Subject: CM/27/18/PL , CM/30/18/PO

CM/27/18/PL Change of Use from farm shop (sui generis) to pet shop (A1)

CM/30/18/PO Modification of planning obligation to allow for use as a pet shop

PLAN 1. BAIRD'S FARM SHOP DEMISE.

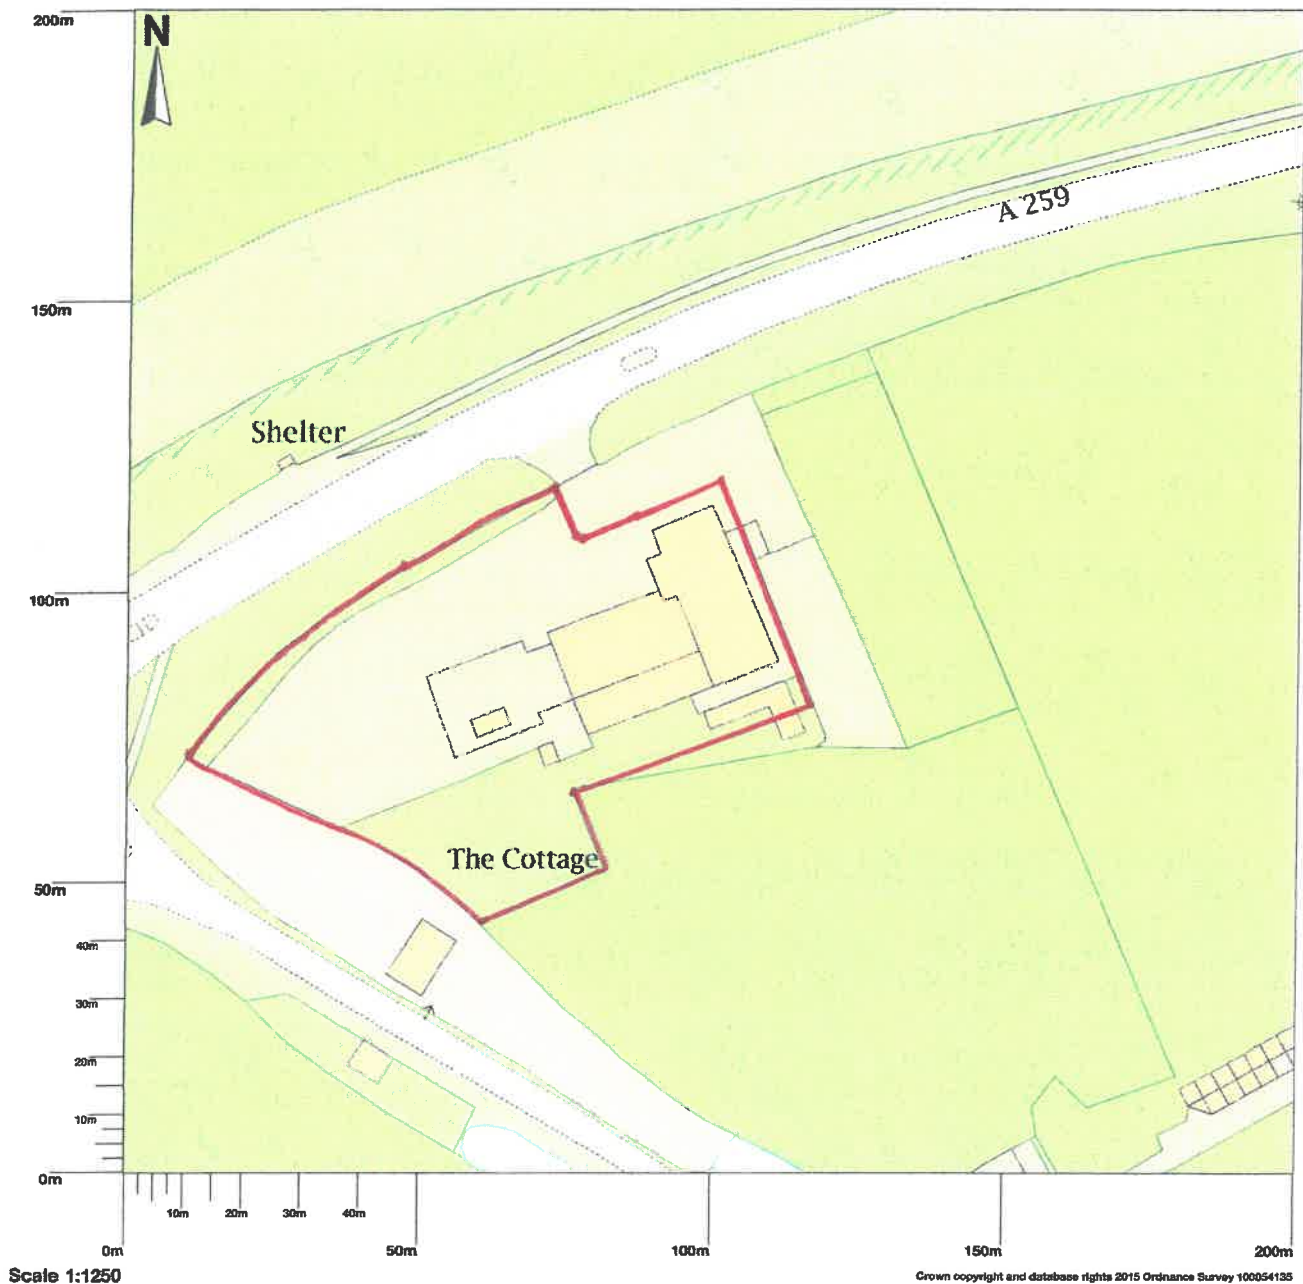
The Site Plan should include the parking area, all parts of the building included in the application, including storage areas and the site access to the A259 within the red edge. You will also need to serve Notice on West Sussex County Council and submit Certificate 'B' to us. Application CM/27/18/PL will be put back on hold until this is resolved.
